MECKLENBURG COUNTY
Park and Recreation Department

MEMORANDUM

DATE: September 22, 2021

RE: Rezoning Petition #2021-161 – Ardrey Kell

Sheet No:
RZ-1

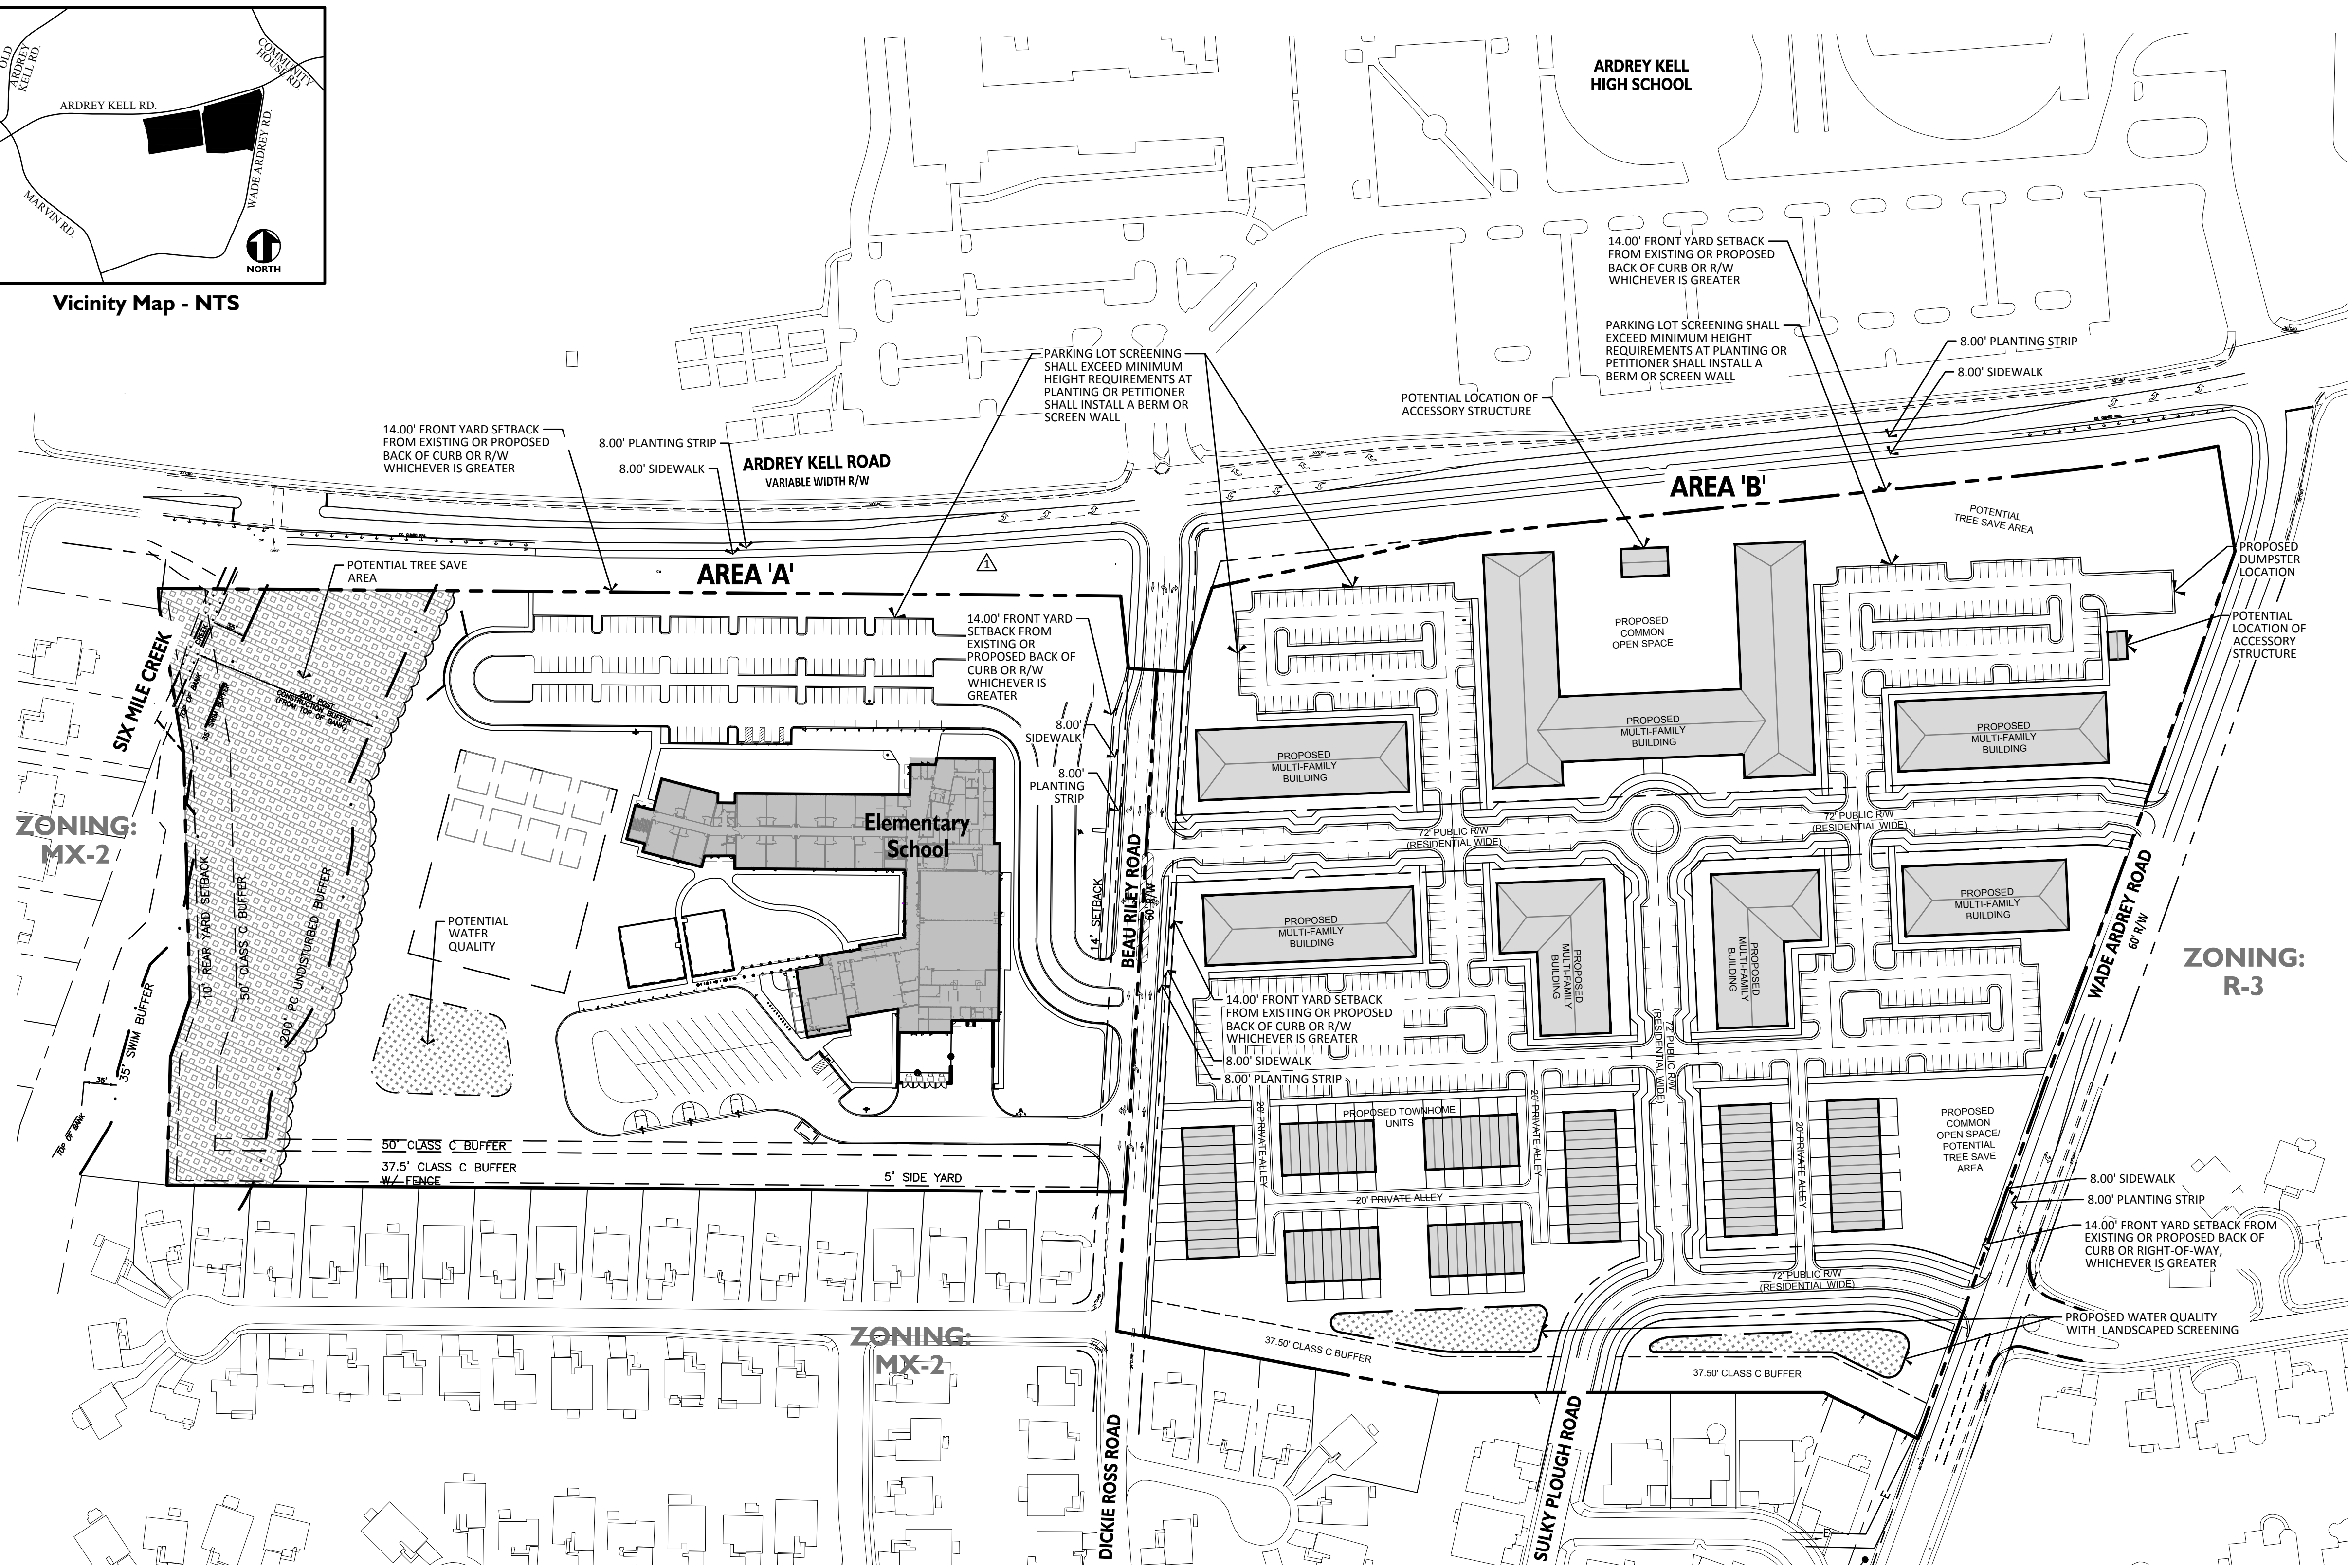
MCPR requests the petitioner dedicate and convey or provide a greenway and storm water easement or a minimum of 100' width adjacent to Six Mile Creek Tributary from Ardrey Kell Lane to the southern property boundary. Trail dedication can overlap with tree save areas. Contact MCPR with any questions/comments.
